## ASSESSMENT REPORT

### Block 11 - Central Park, Chippendale SSD 6376 MOD 2

This report is an assessment of an application seeking to modify the State significant development (SSD) consent (SSD 6376) for a mixed-use development known as Block 11 at Central Park, in the Sydney local government area.

LEVEL 7

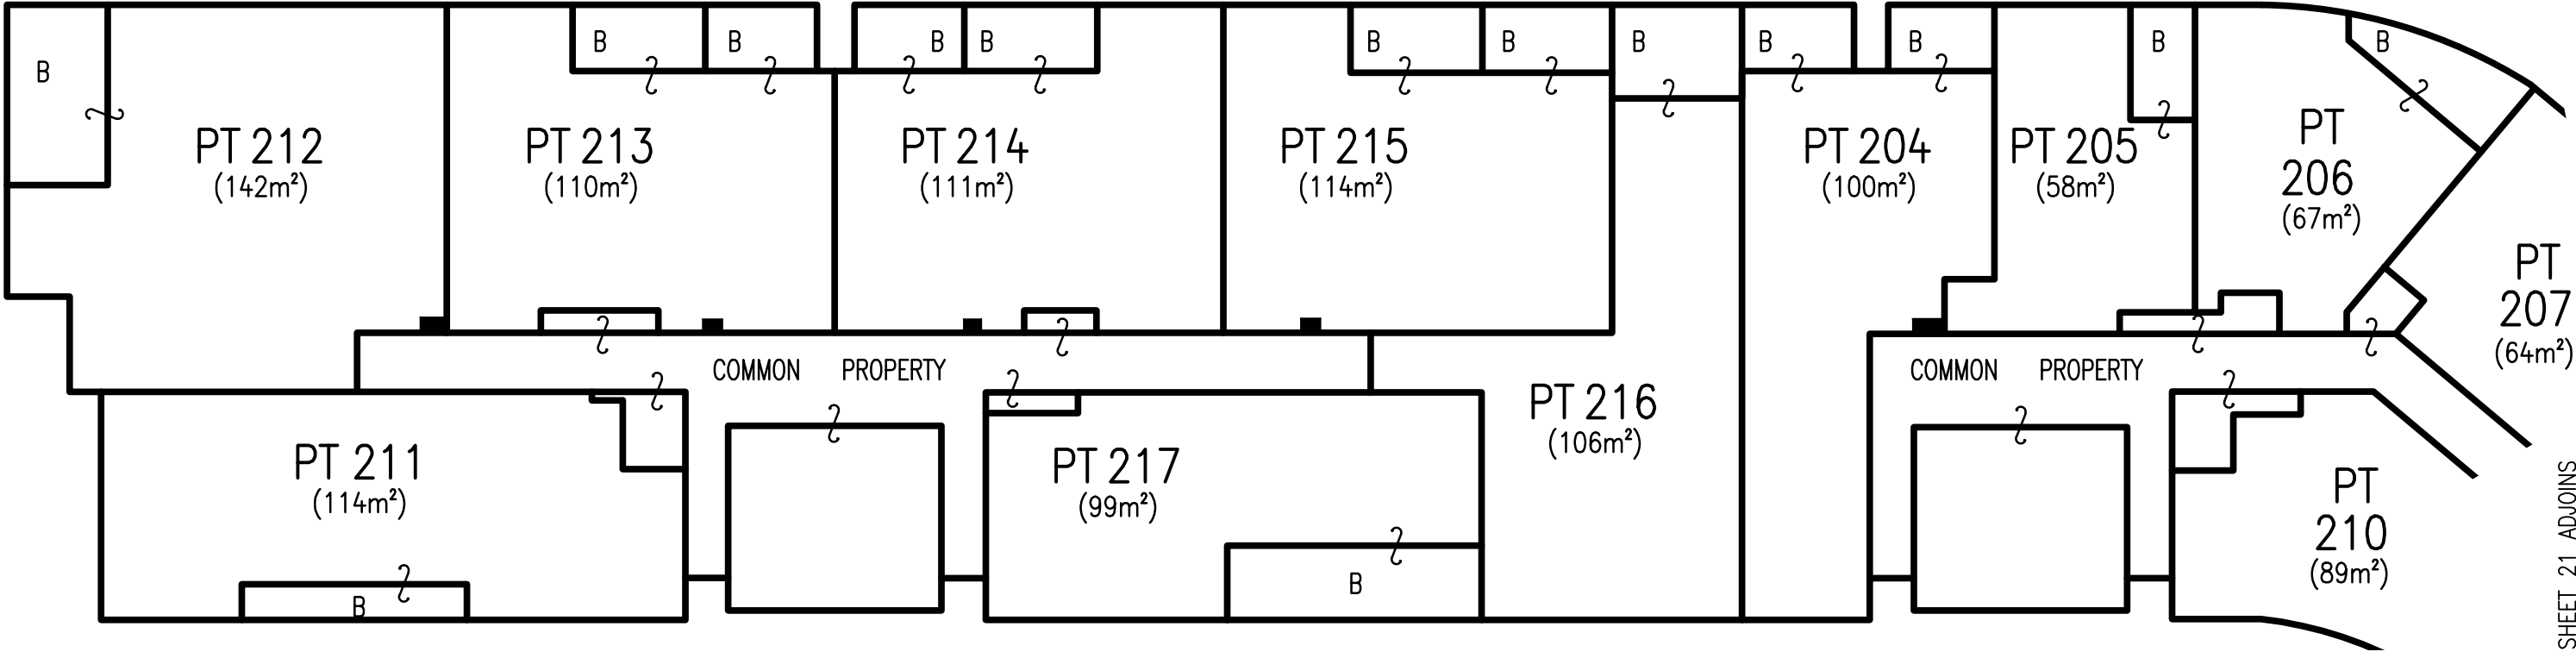
The Department notes two of the proposed 1-bedroom apartments are 6 m<sup>2</sup> below the ADG minimum size requirement. The Department raised concern about the amenity of these apartments and in response, the Applicant agreed to amend the apartments to address the shortfall. The Department recommends a new condition requiring the submission of amended plans to ensure these apartments comply with the ADG minimum size requirements.
